Proposed new Bank Building (Southwest Capital Bank)
Located at the SE Corner of Central Avenue and 15th Street
1410 Central Ave (a.k.a. 120 15th Street) Albuquerque NM 87104

Project # 1009118, Case # 12 EPC 400002

RMKM submitted a site development plan for building permit to the City of Albuquerque's Environmental Planning Commission. The project was approved with conditions on April 12th, 2012. This letter serves to list all changes which have been made to the EPC approved drawings.

**AFD PLANS CHECKING OFFICE**  
 924-3611  
**APPROVED/DISAPPROVED**  
 HYDRANT(S) ONLY  
 [Signature]  
 SIGNATURE & DATE

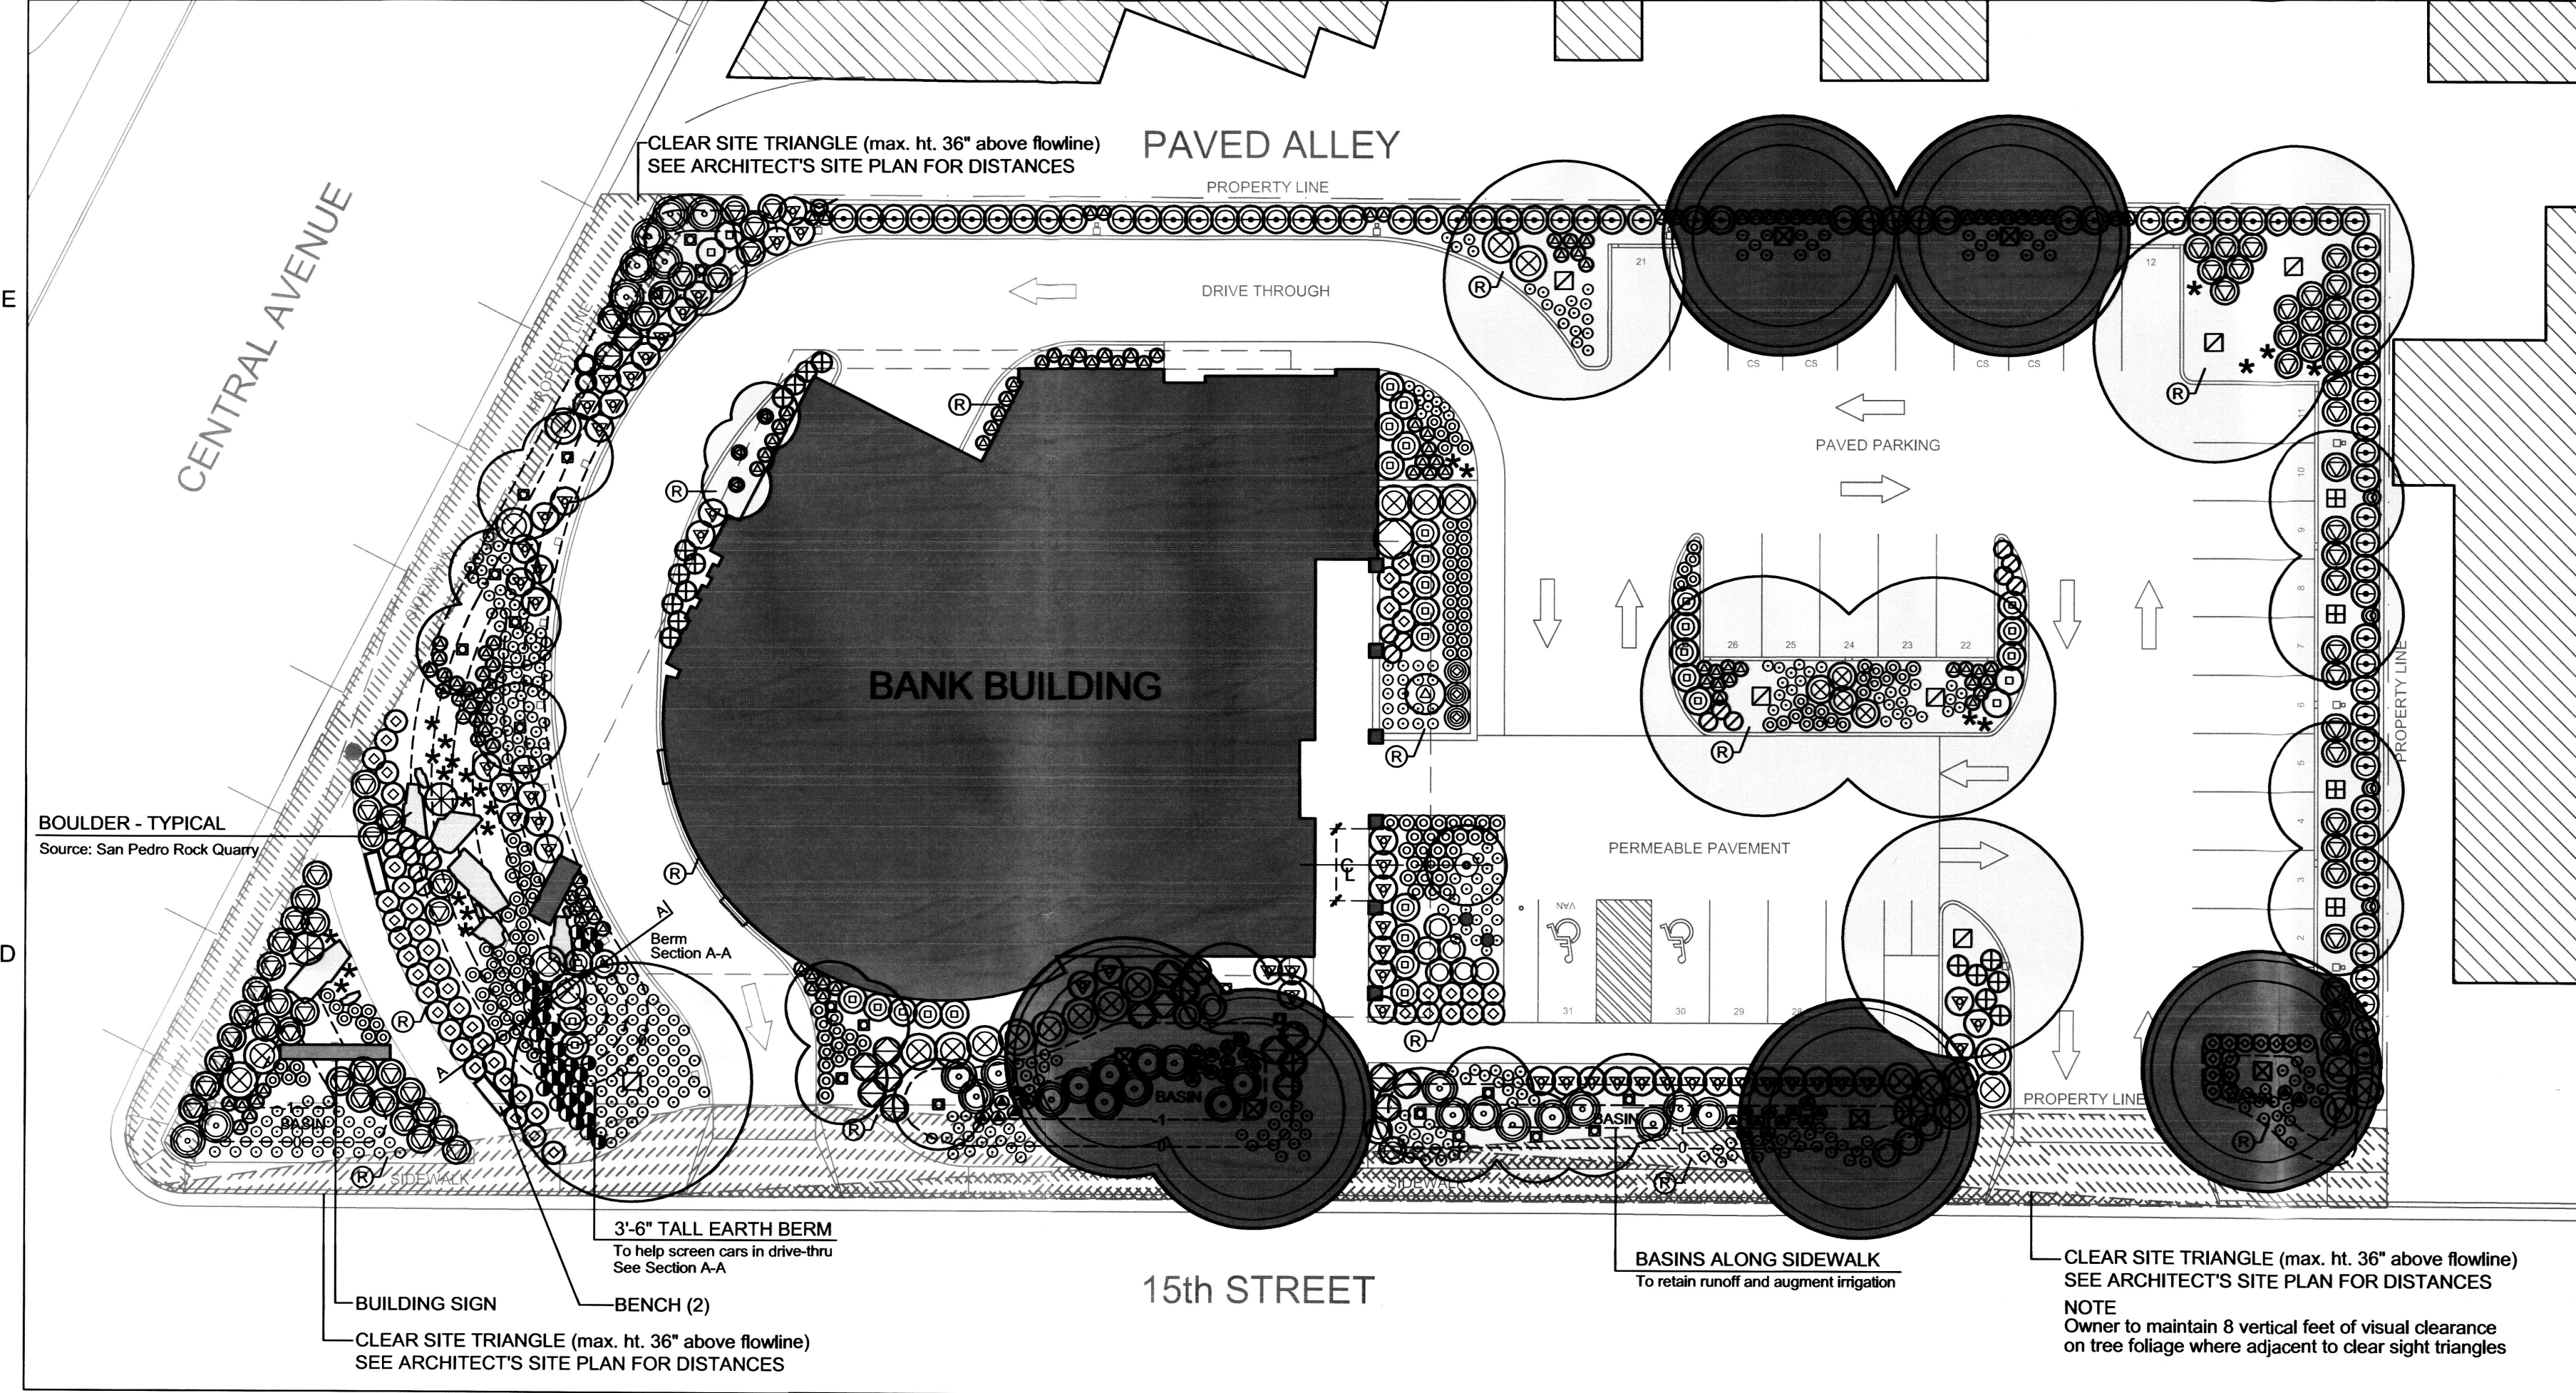
- 3. The applicant shall provide outdoor space for the public at the primary entrance (south side) of the building (Section 14-16-3-18)(C)(3)). Two benches have been included at the building's SW corner adjacent to the main southern entry.

- a. Provide a sight distance exhibit at the existing curb cut along Central. The proposed wall may need to be lowered in this area. A 35' clear site triangle is indicated with revised plantings of a maximum 30" height.

- b. Pavement markings and signage must be provided for the drive through exit. One way pavement markings are indicated and do not enter traffic signs are indicated at the drive through exit.

**1 LANDSCAPE PLAN** Plant symbols on plan show plants at approximately mature size  
Scale: 1" = 20'-0"

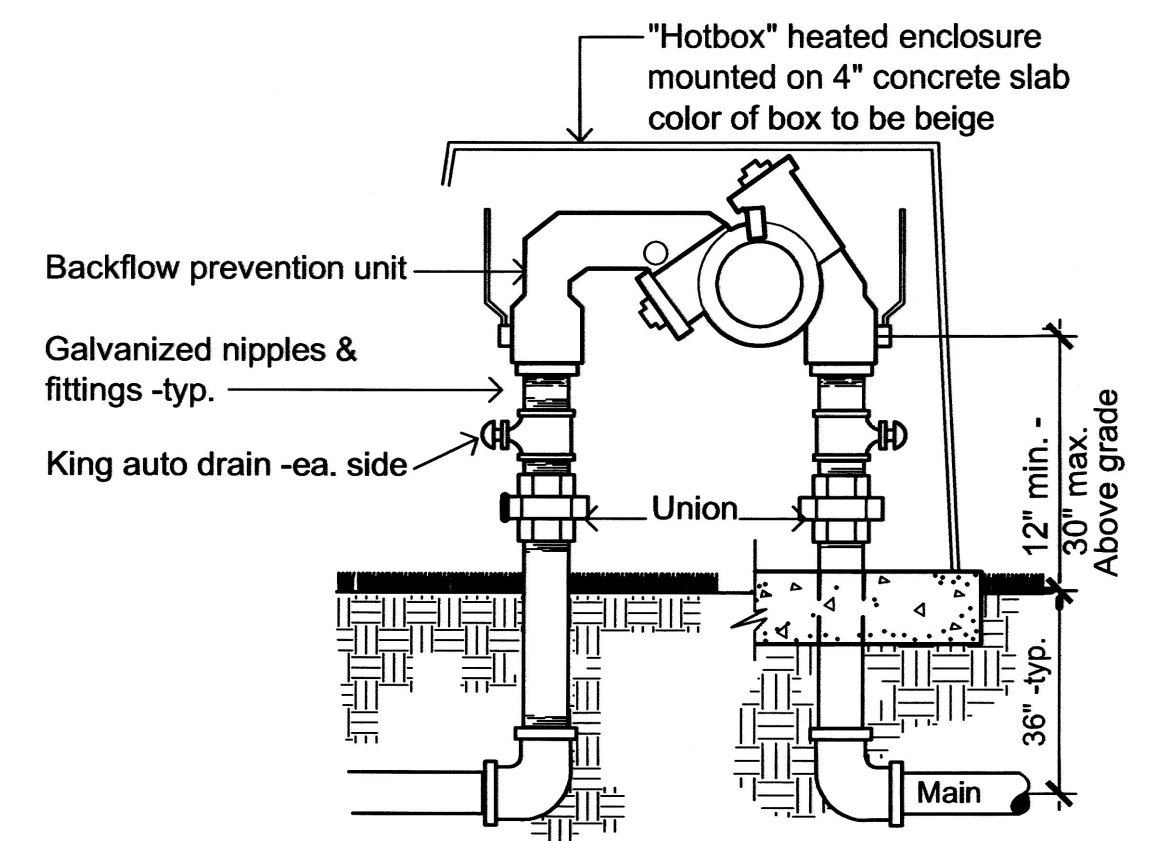
- a. The applicant shall meet the Zoning Code requirement (Section 14-16-3-10) (G)(1)(d) that "At least 75% of the required parking area trees shall be deciduous canopy-type shade trees, capable of achieving a mature canopy diameter of at least 25 feet." The calculation showing 83% deciduous trees in the parking area has been included.

- b. The Plant Schedule on the Landscaping Plan shall contain a category for Water Use for all plants. Landscaping which is high water use shall be avoided. The plant schedule has been modified to include water use, high water usage plants have been avoided.

- c. The ground cover referred to as "Dward plumbago" shall be spelled "Dwarf plumbago." The spelling of Dwarf plumbago has been corrected.
- d. The number of Street Trees "required" and "provided" shall be shown on the Landscaping Plan. The calculation showing required and provided street trees has been provided.

- e. Two additional evergreen trees shall be added to the east side landscaping strip next to the alley, in between the proposed Afghan Pine and Shumard Oaks. Two additional Afghan pines have been added to the east of the parking area.

④ WEST ELEVATION  
 1/8" = 1'-0"

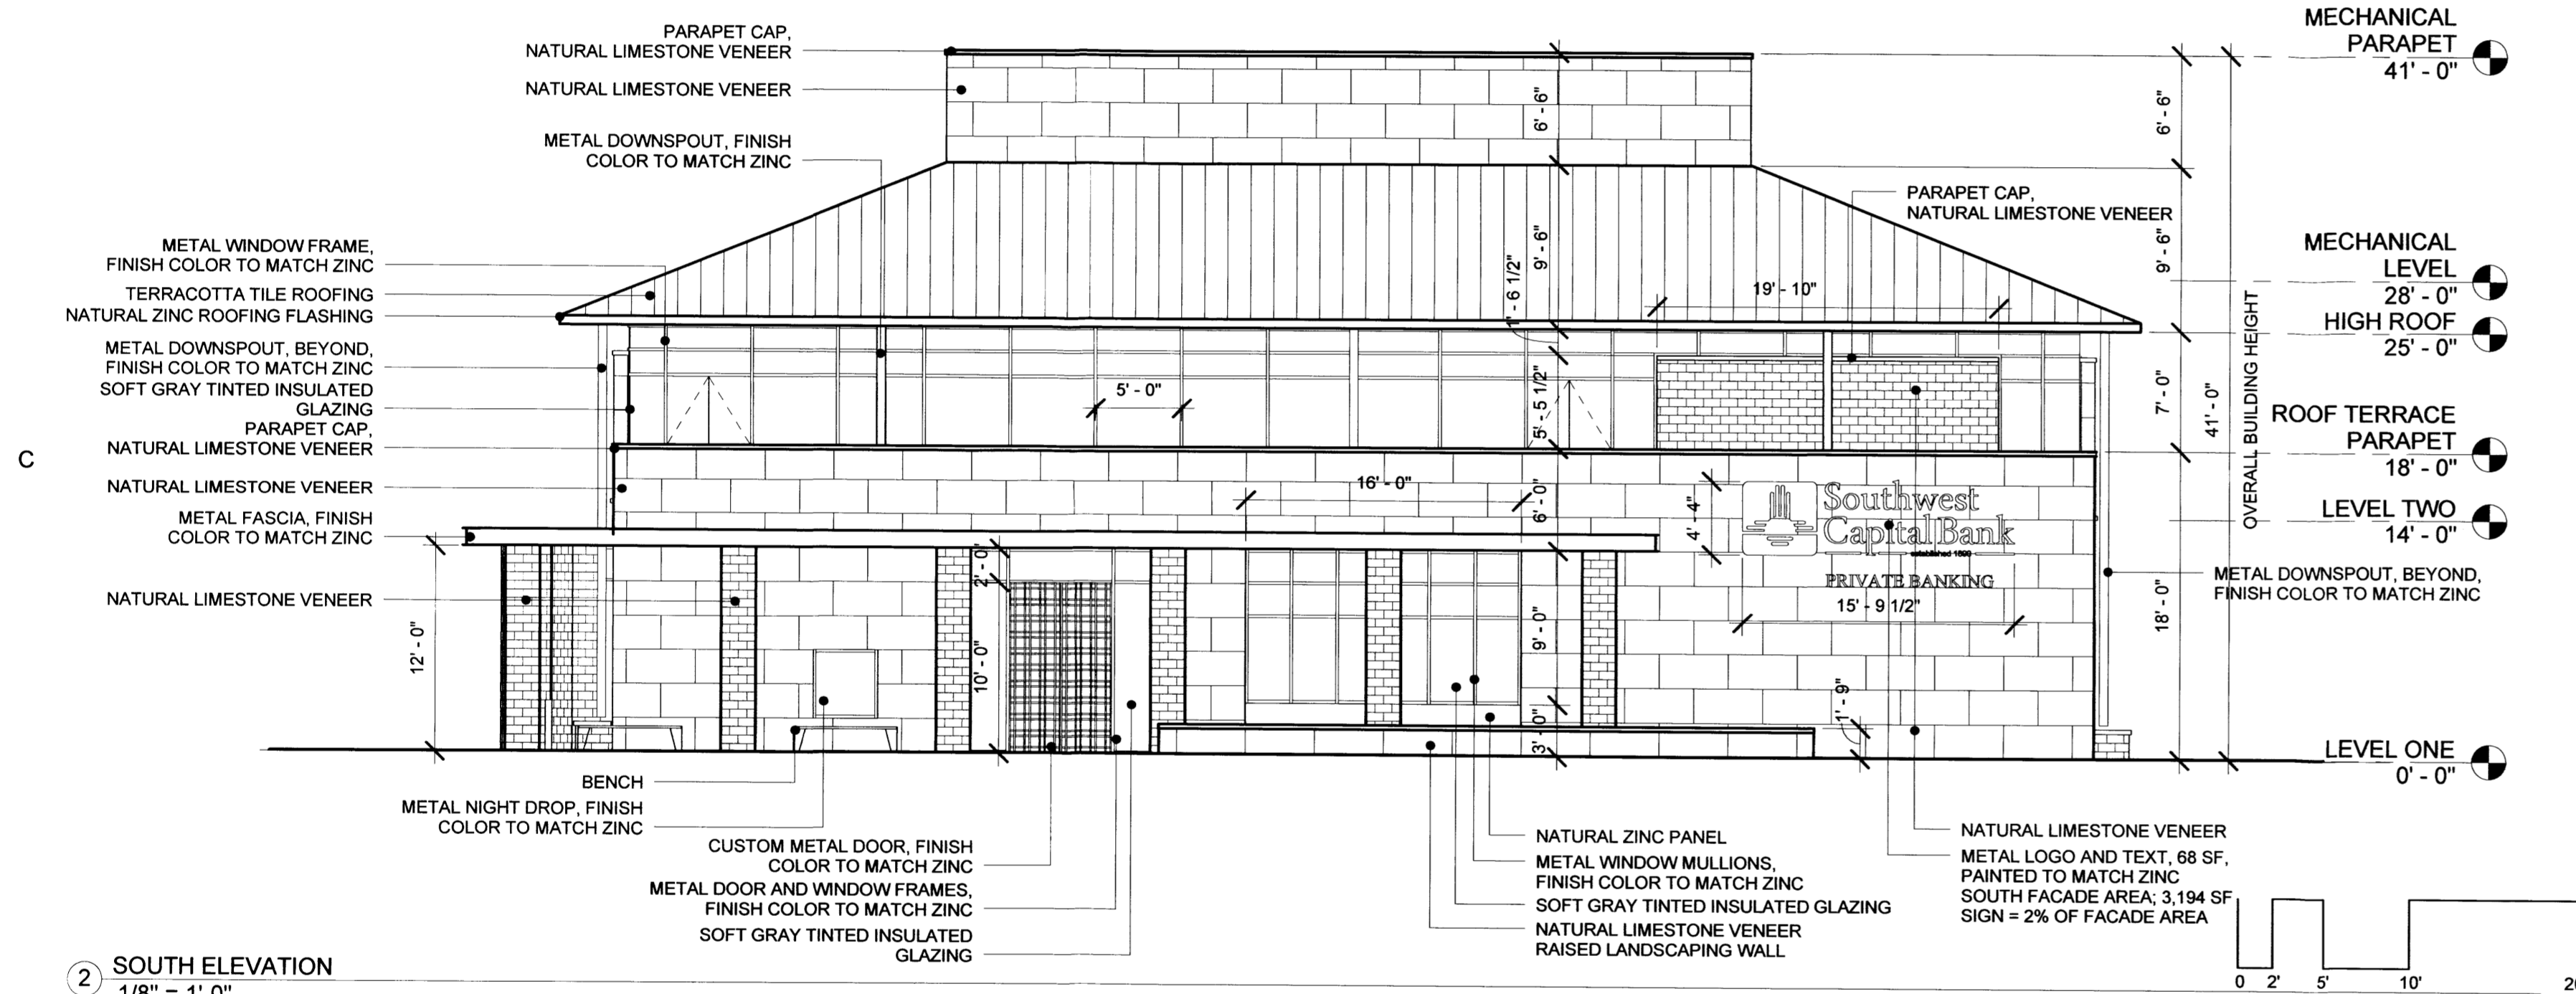
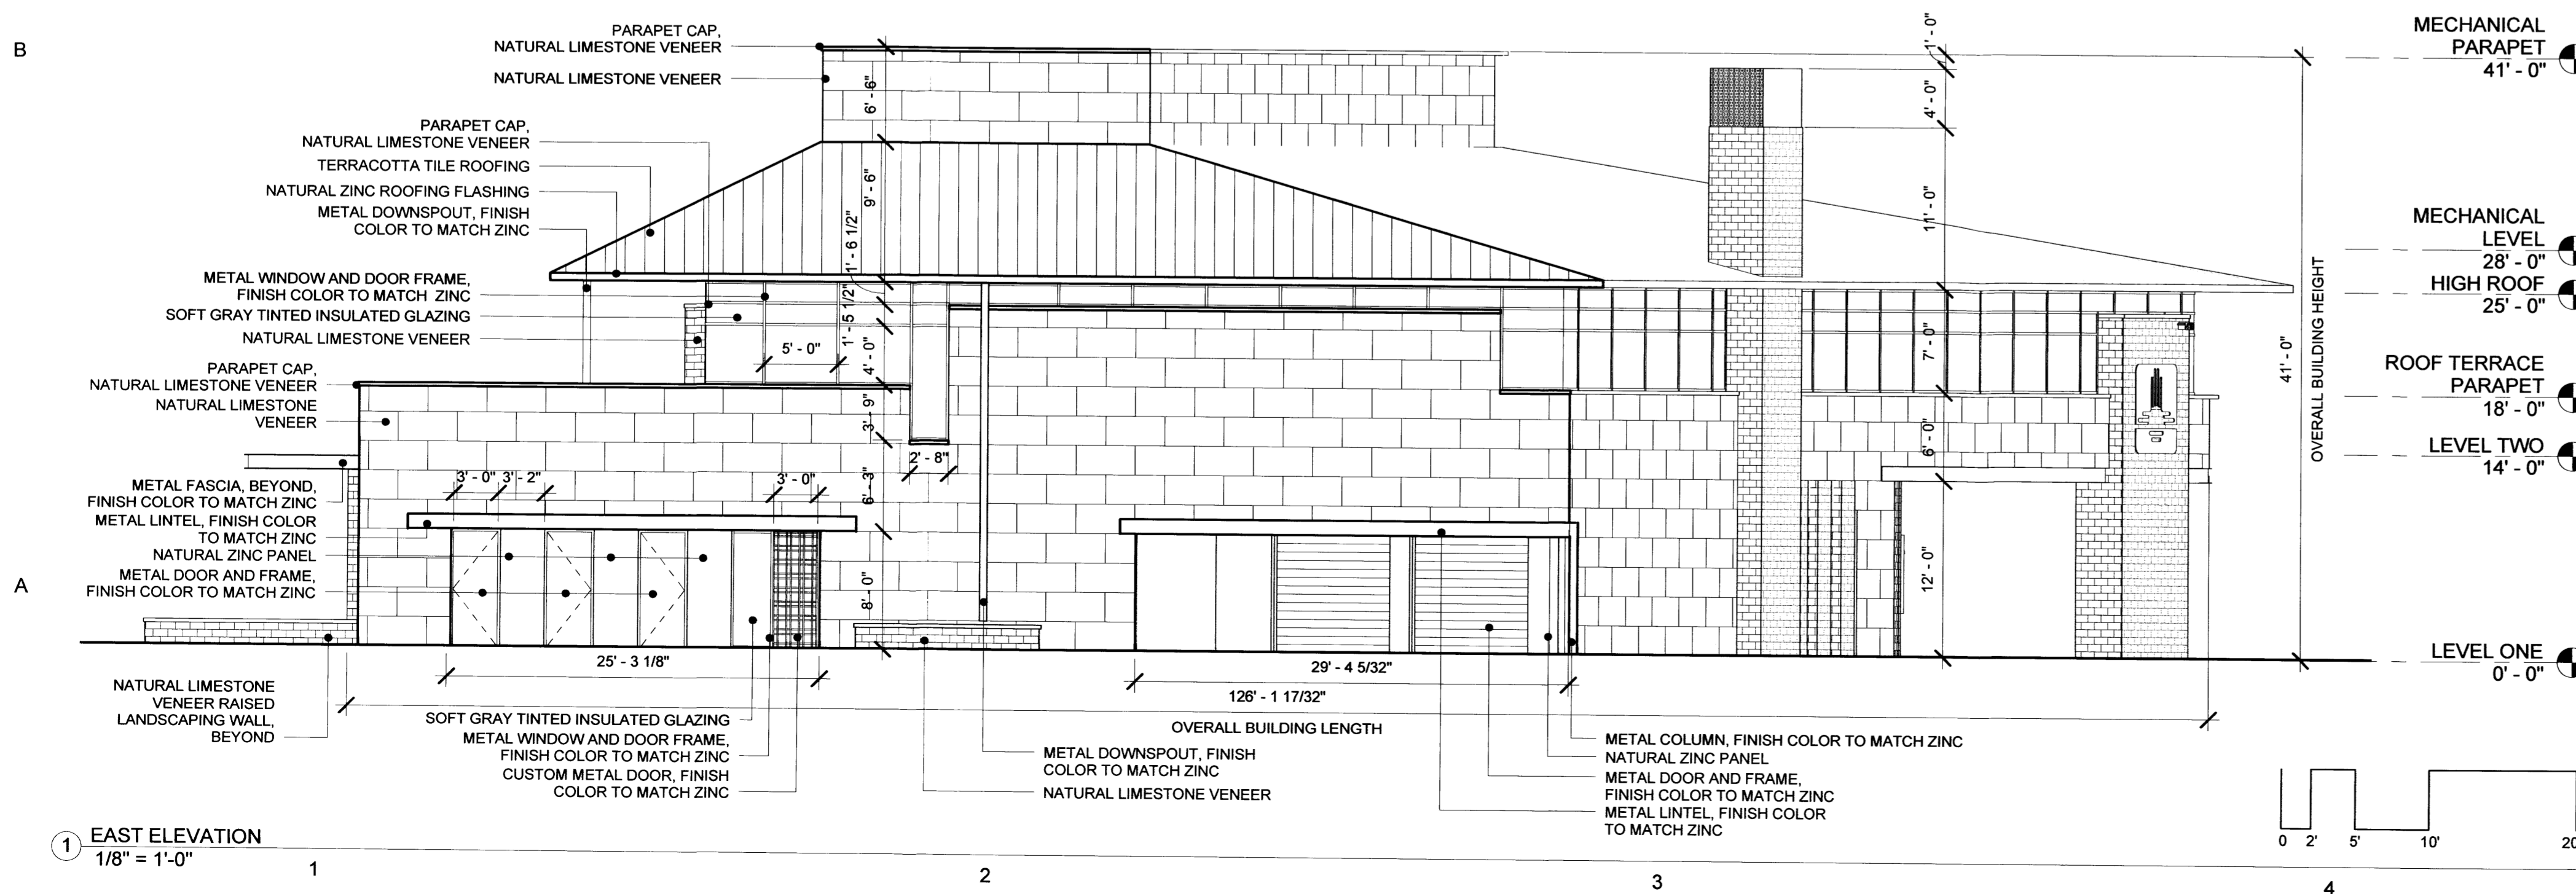
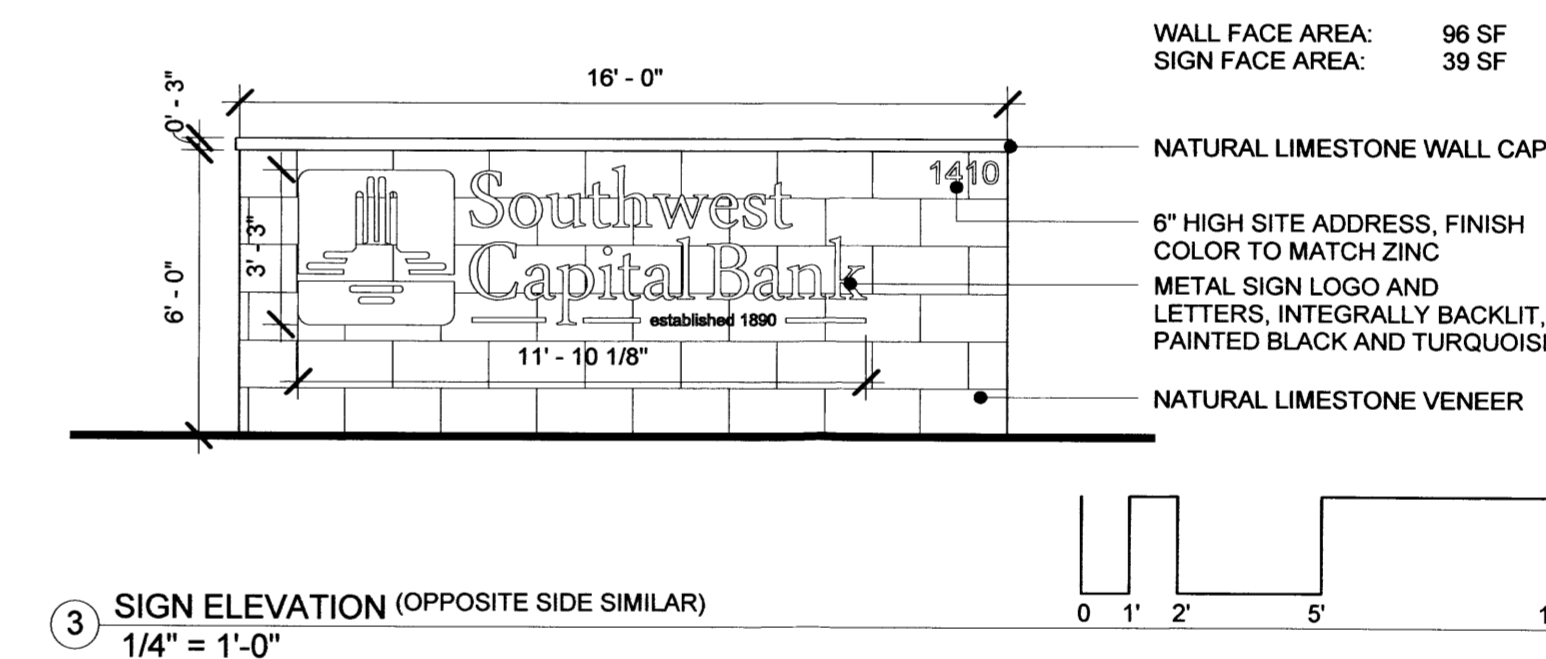
- 5. The "common name" colors of the building shall be shown on the Elevations Sheet. The common name colors of materials have been included.
- 6. Conditions of Approval from City Engineer, Municipal Development, and NMDOT:
